**EPA Advice on Submissions Report
NextDC S5 Data Centre – SSD-63168959**

I am writing in response to your request for advice from the NSW Environment Protection Authority (EPA) on the Submissions Report for the proposed Next DC S5 Data Centre at 269 Lane Cove Road, Macquarie Park.

Figure 2 – The Proposal's standby generator stack locations

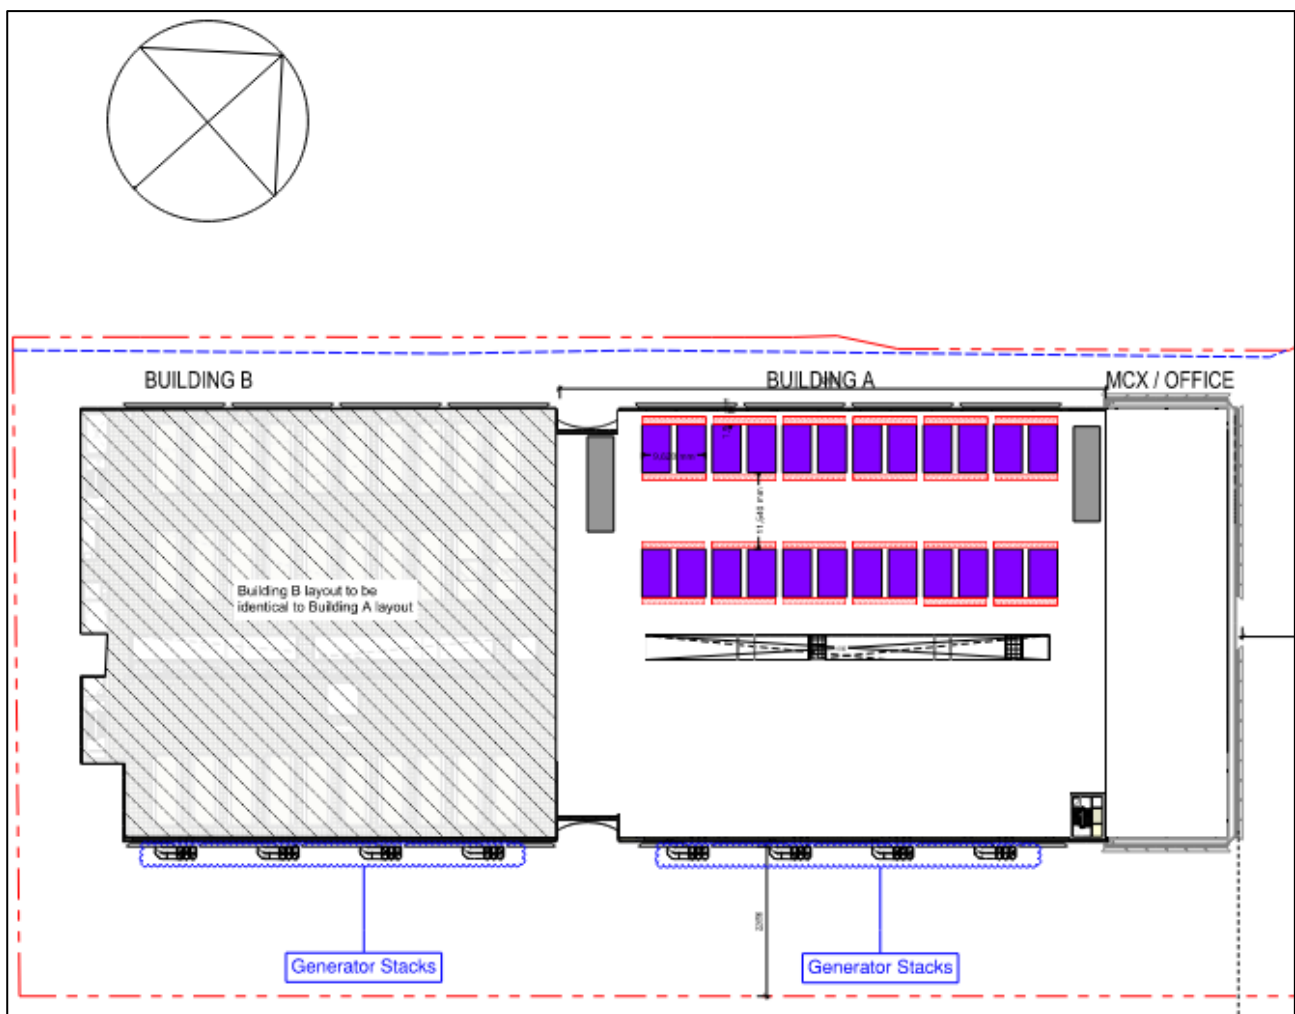
The Technical Note does not appear to address all potential generator operation, including:

- Justification of why no warm-up time has been included in calculating operating hours,

- Details of any diesel generator operation associated with routine facility and infrastructure maintenance,
- Allowance for unplanned generator use, particularly with regard to any circumstances that involve facility/infrastructure issues or network voltage disturbance, grid firming or load shedding,
- Any plant warranty requirements – noting reduced cool-down periods and a single annual test for generator maintenance is proposed.

The EPA advises the Air Quality Impact Assessment should model the reasonable worst-case operating scenario. Consideration should be given to whether multiple generators will be required for routine activities like maintenance of facility, site or network infrastructure. Where this is identified, the proposal should revise modelling and consideration of cumulative impacts with other data centres, to address the potential risk of additional exceedances of air quality assessment criteria.
